# V1Final Plat Drawings.pdf Markup Summary

SITUATED IN THE SOUTHWEST QUARTER OF SECTION 6 AND THE NORTHWEST 1/4 OF SECTION 7, TOWNSHIP 15 SOUTH, RANGE 65 WEST OF THE 6TH P.M.,
 COUNTY OF EL PASO, STATE OF COLORADO
 SHEET 4 OF 5
 PROPOSED EASEMENTS

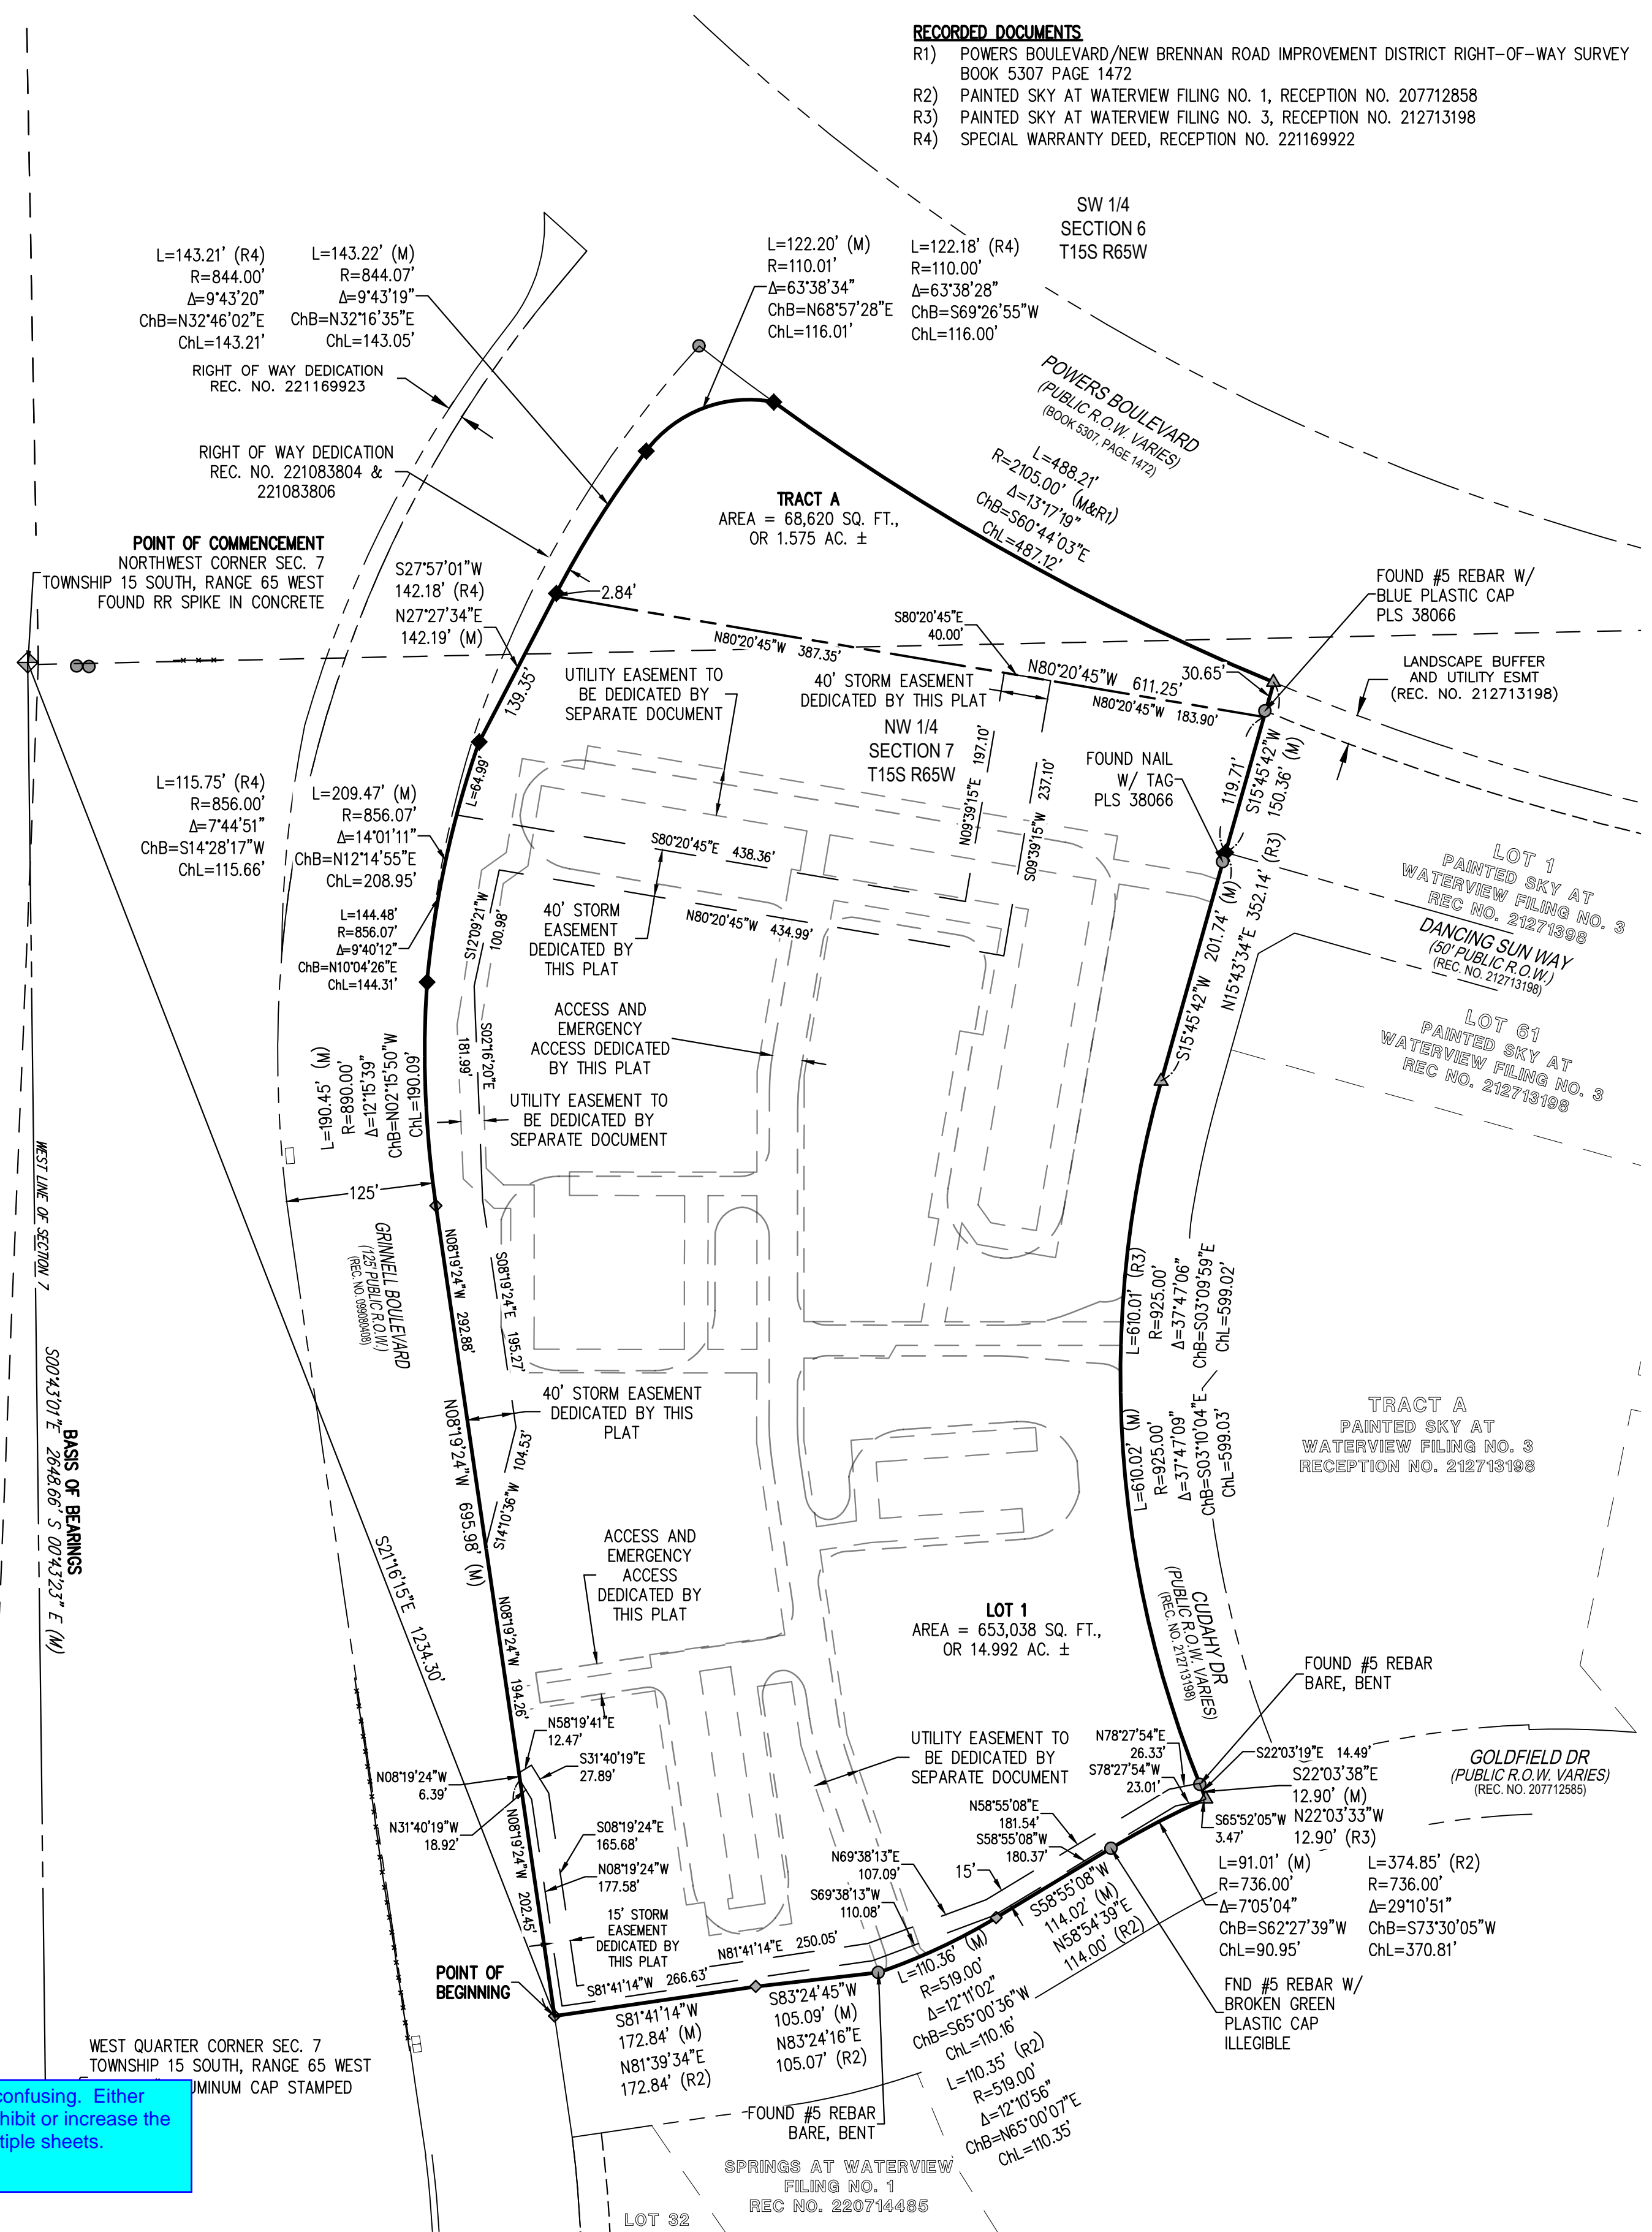
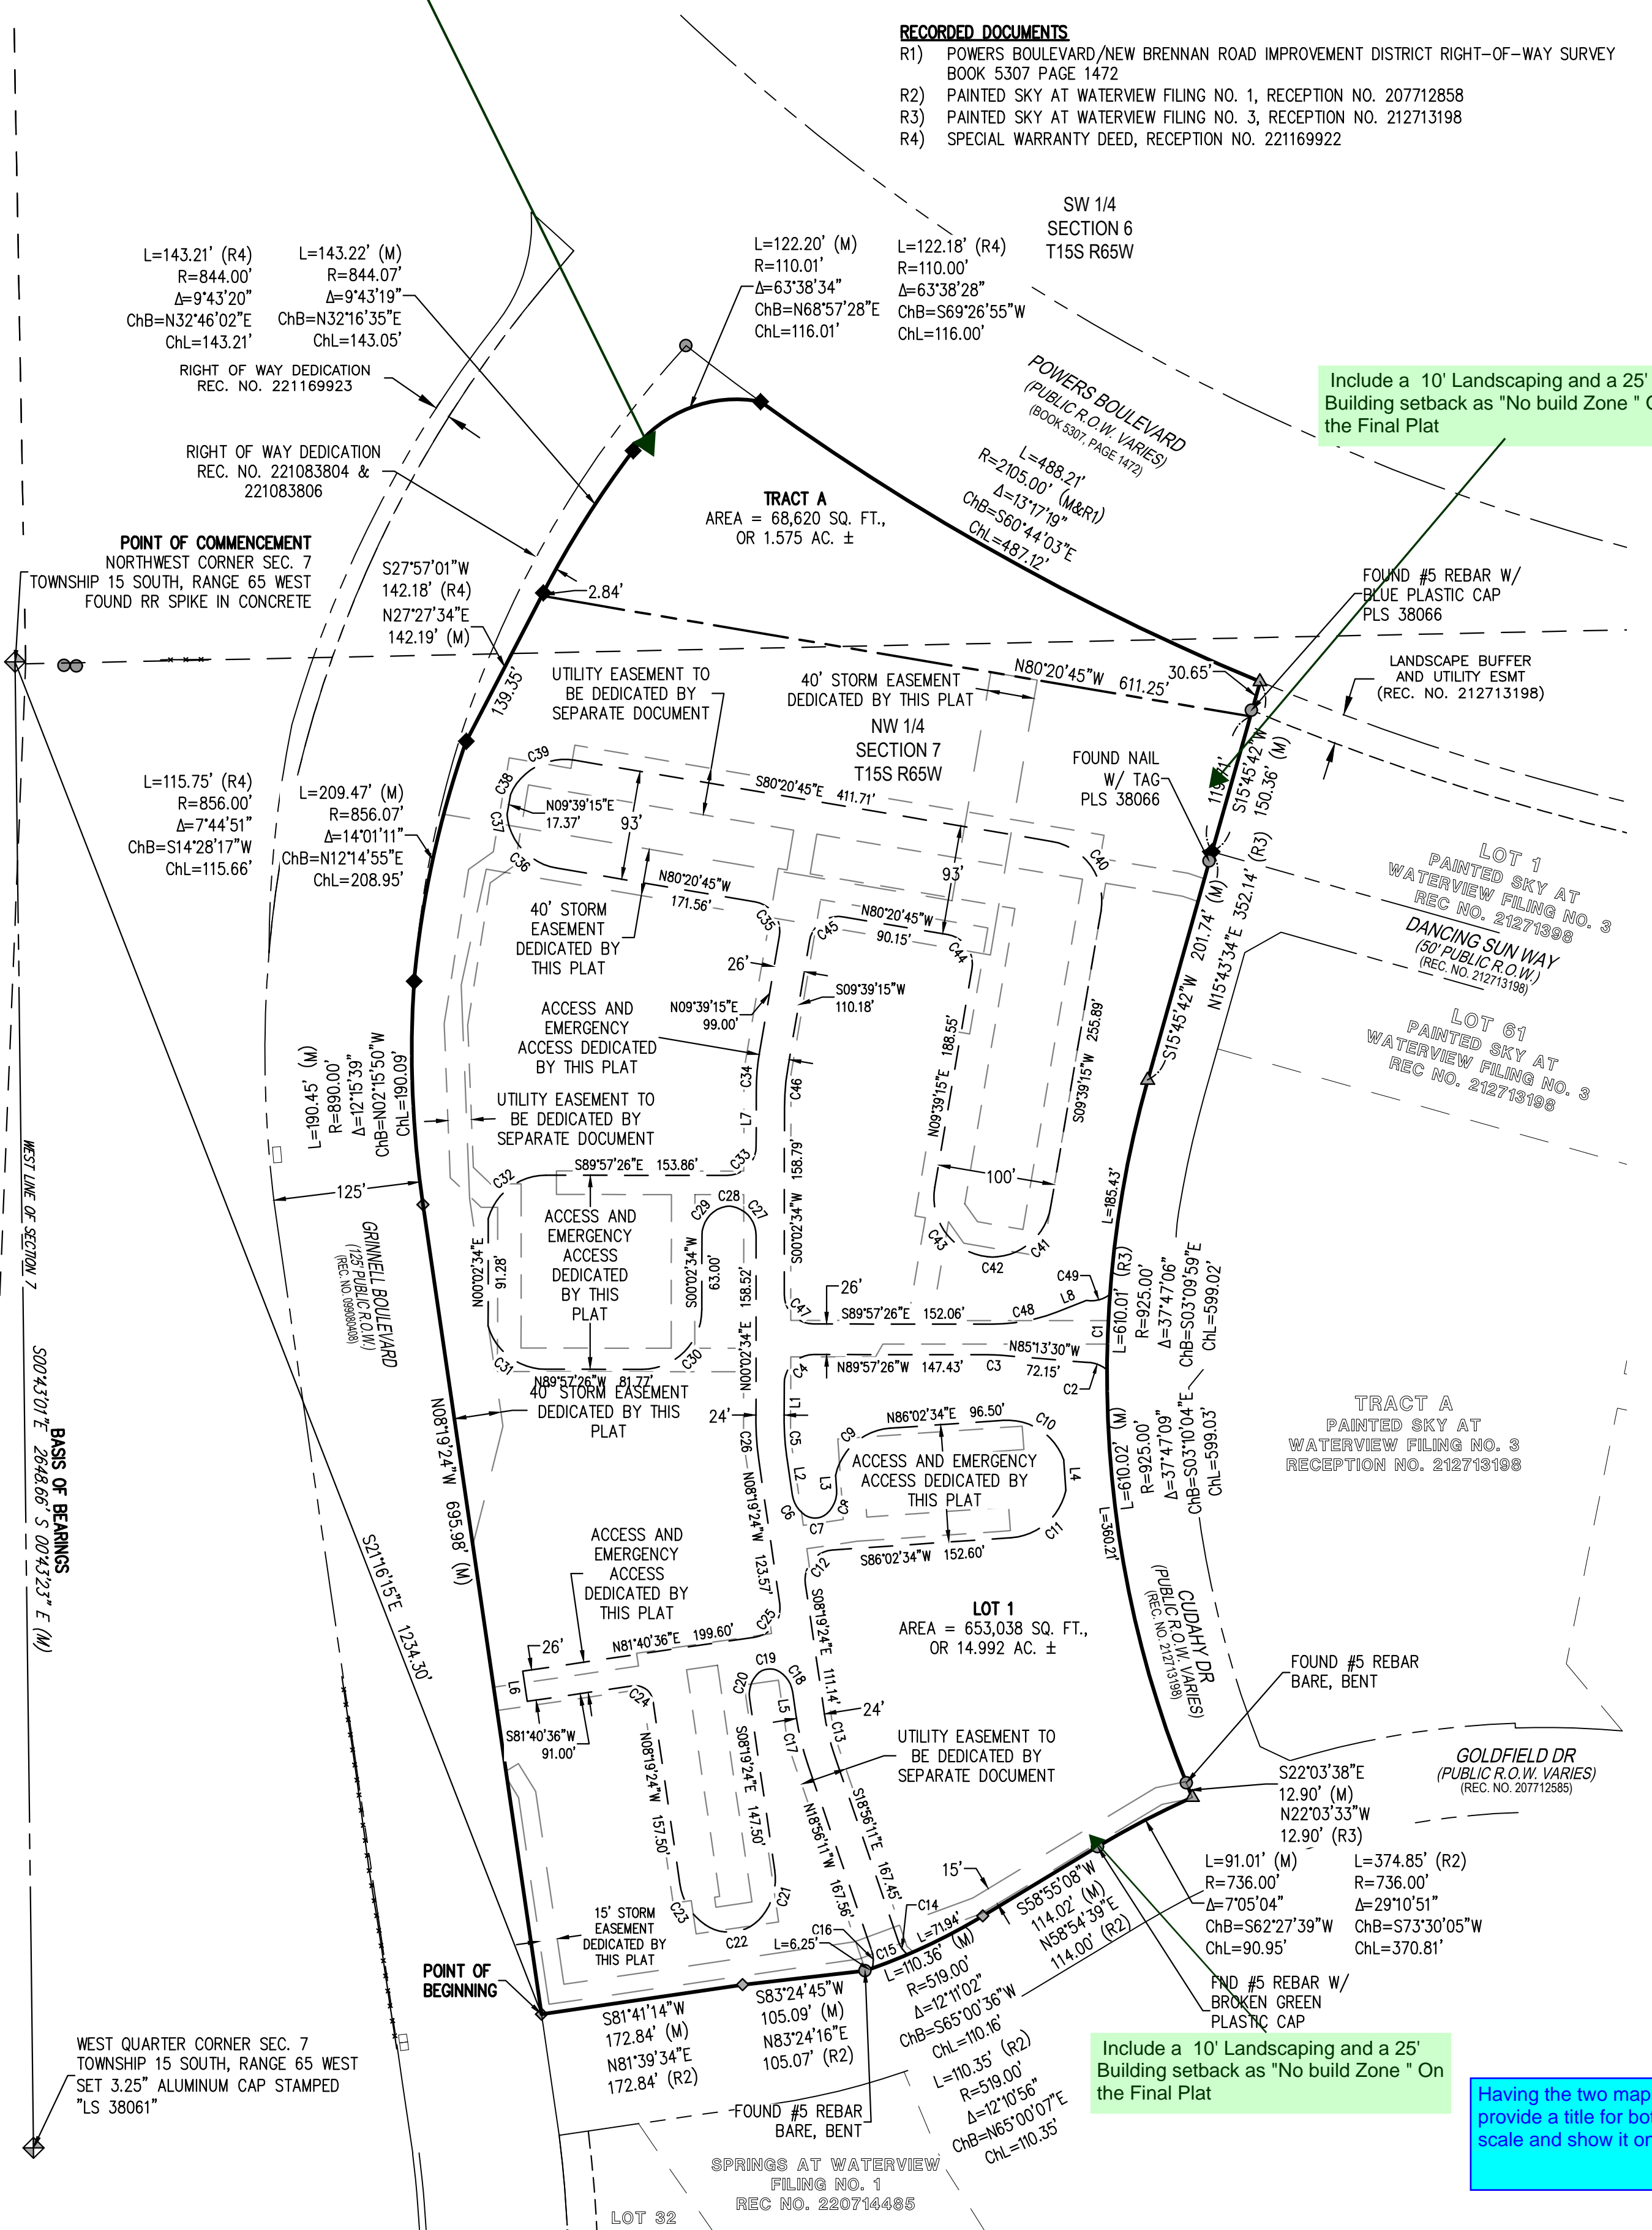
Having the two maps is confusing. Either provide a title for both exhibit or increase the scale and show it on multiple sheets.

Include a 20' Landscaping and a 25' Building setback as "No build Zone " On the Final Plat

Include a 10' Landscaping and a 25' Building setback as "No build Zone " On the Final Plat

Include a 10' Landscaping and a 25' Building setback as "No build Zone " On the Final Plat
